CITY OF ALBUQUERQUE

**Re: The Boulders Phase 1 Pad Certification, Lot 72/ Lot 92 switch,
Engineer's Stamp date: 5-6-11 (B11/D001B)
Certification date: 03-13-12**

Based upon the information provided in your submittal received 03-14-12, the above referenced Certification is not approved for Building Permit transfer on Lots 72 (9605 Boulder Trail) to Lot 92 (9628 Monolith).

RONALD R. BOHANNAN P.E. #7888	THE BOULDERS PHASE 1		DRAWN BY DY
	RETAINING WALLS		DATE 05-06-11
	 TIERRA WEST, LLC 5571 MIDWAY PARK PLACE NE ALBUQUERQUE, NM 87109 (505)858-3100 tierrawestllc.com		2011005-SH01-02- GRE-PH1
			SHEET # 3
		JOB # 2011005

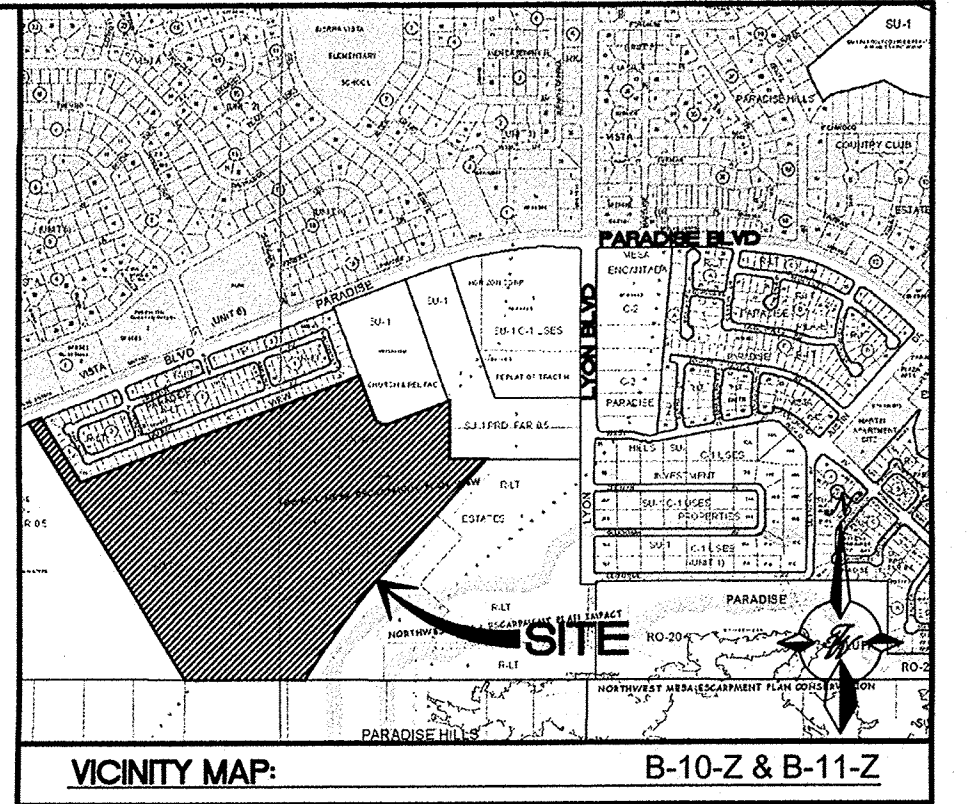
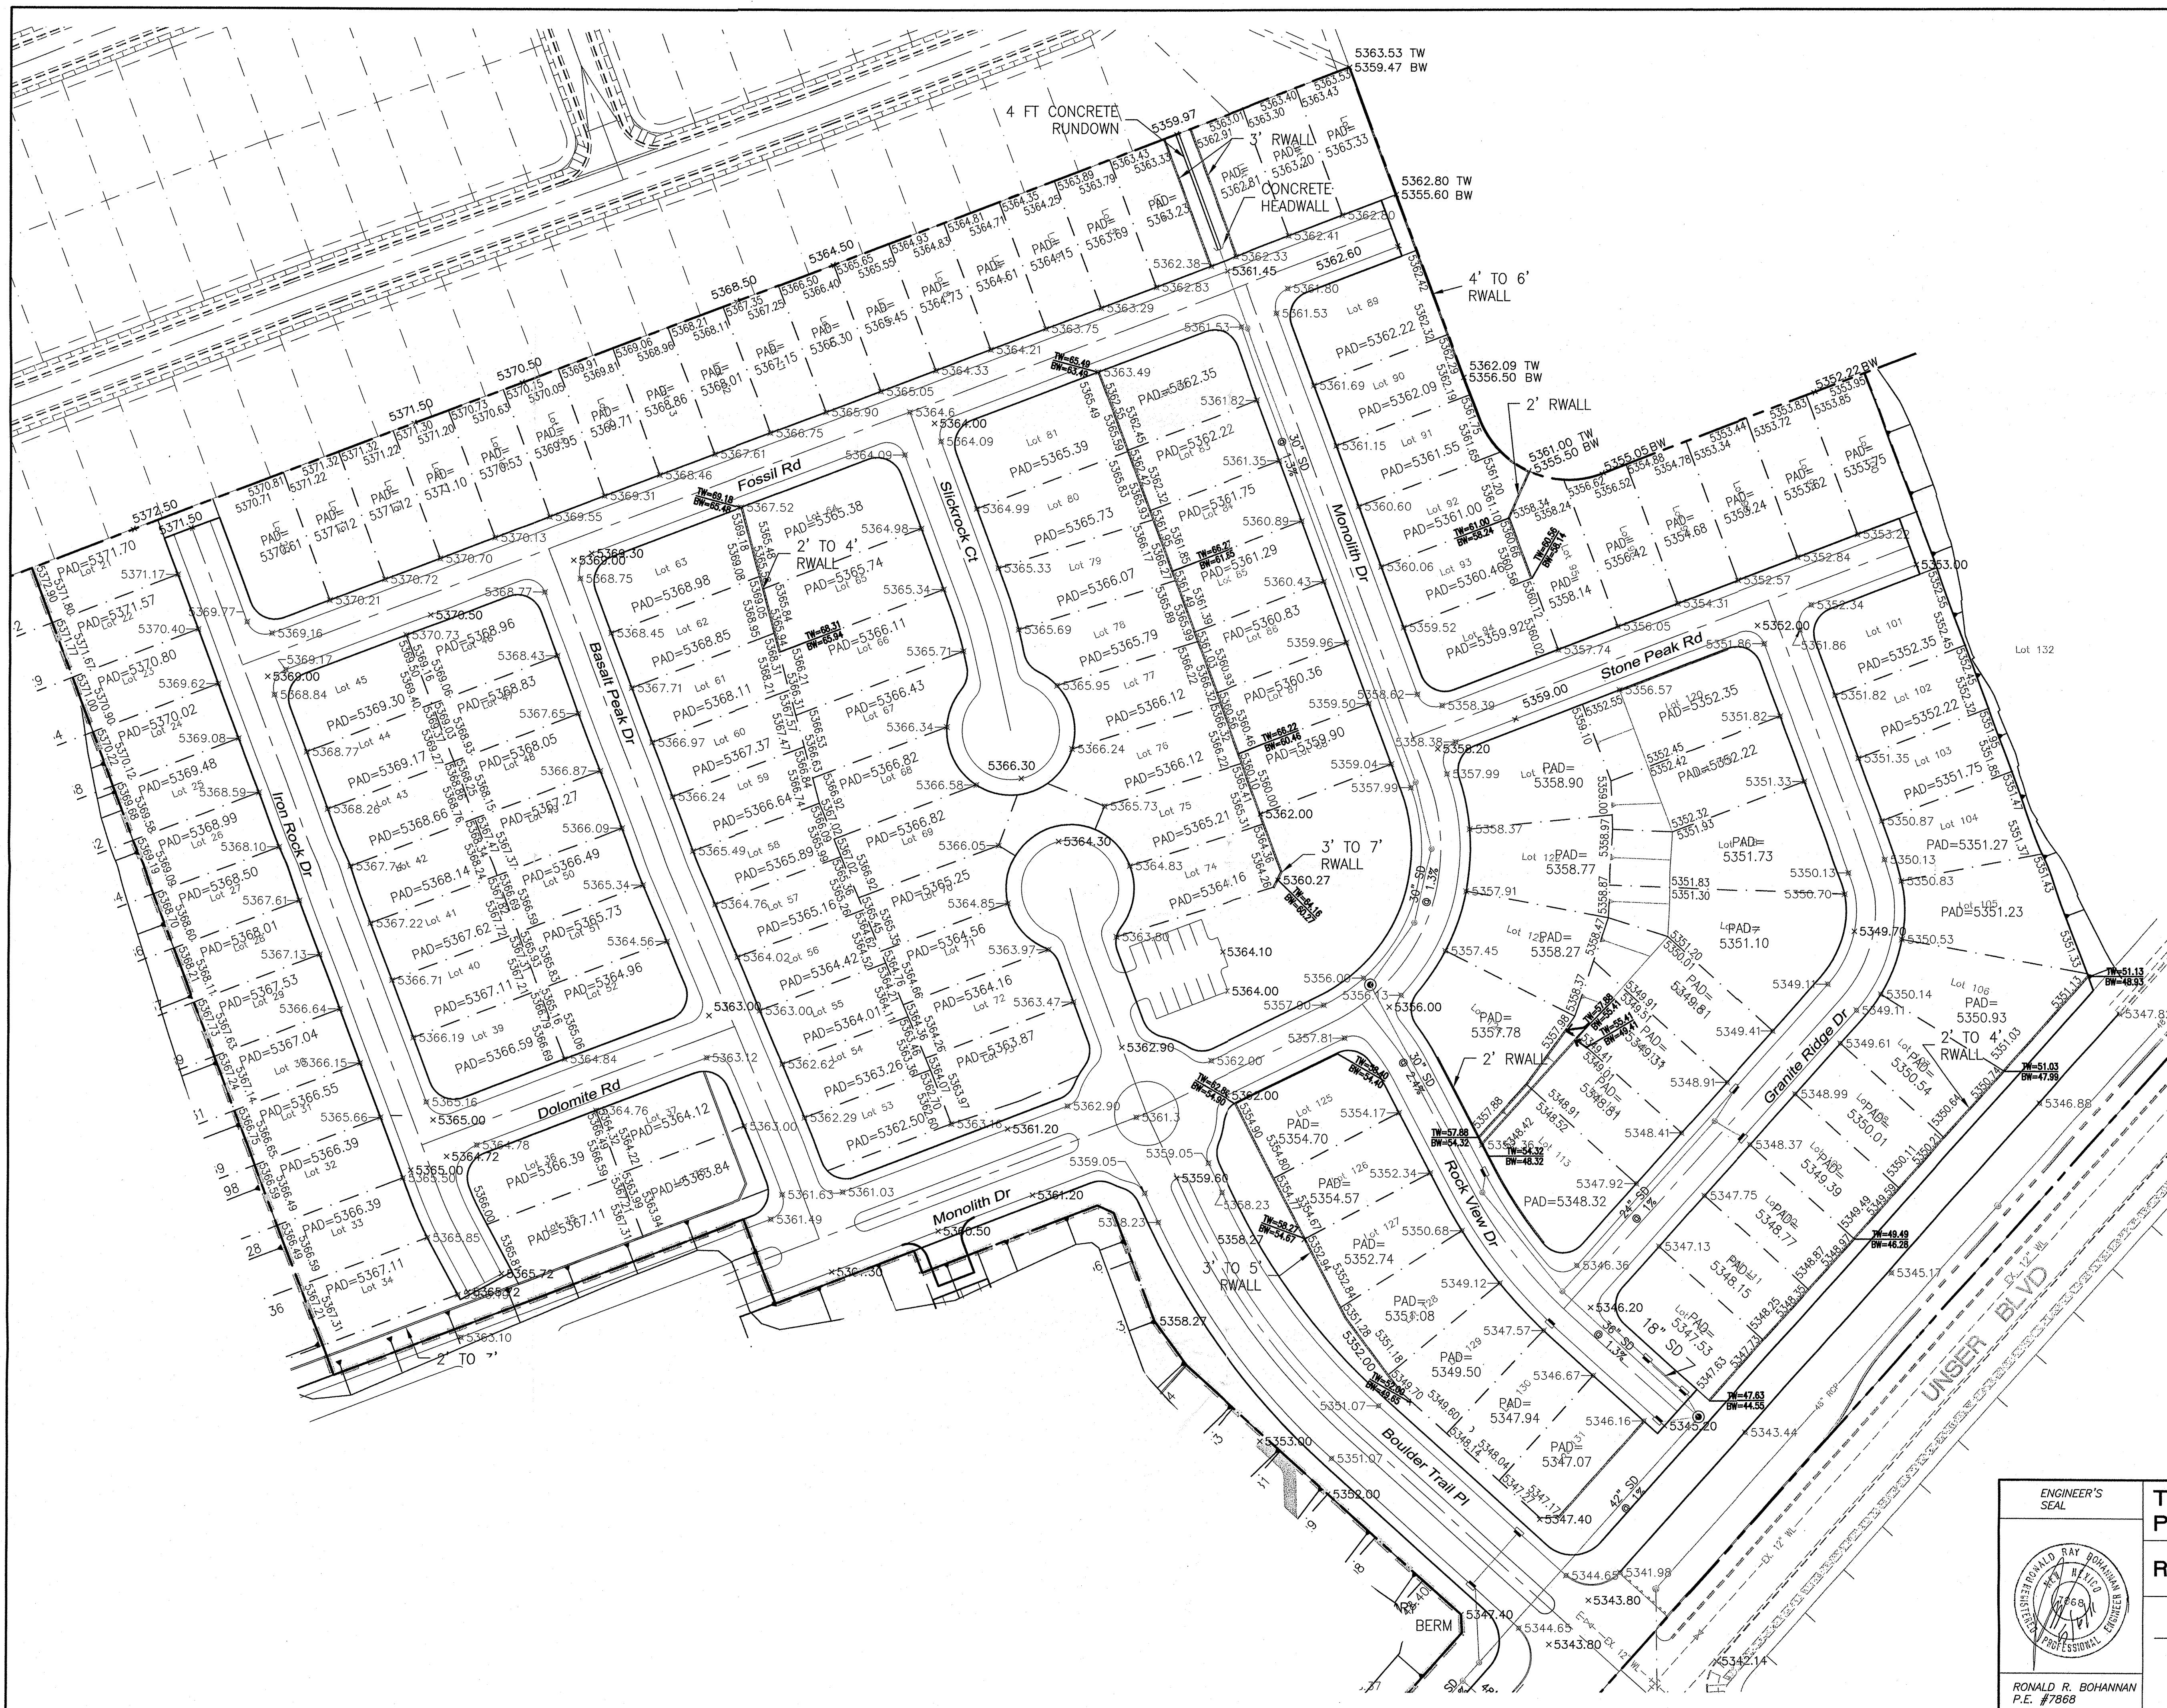
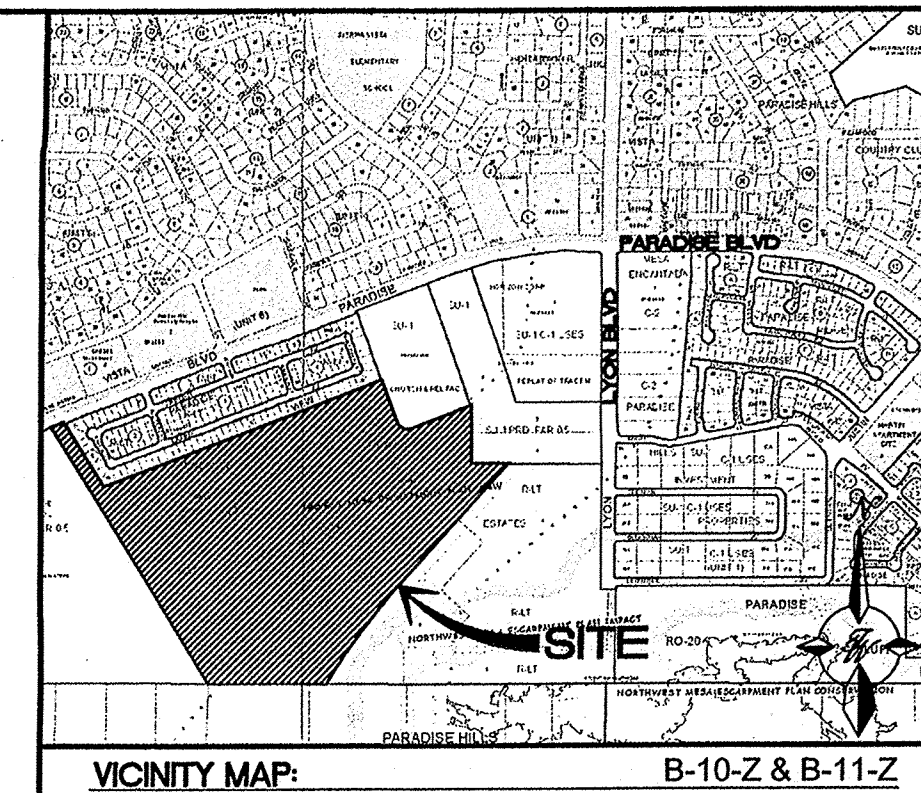
A pad certification requires an as-built grade elevation for all pads being certified, as-built elevations for the retaining walls abutting the rear property lines, and top of curb elevation. In the future please provide all addresses that the certification covers.
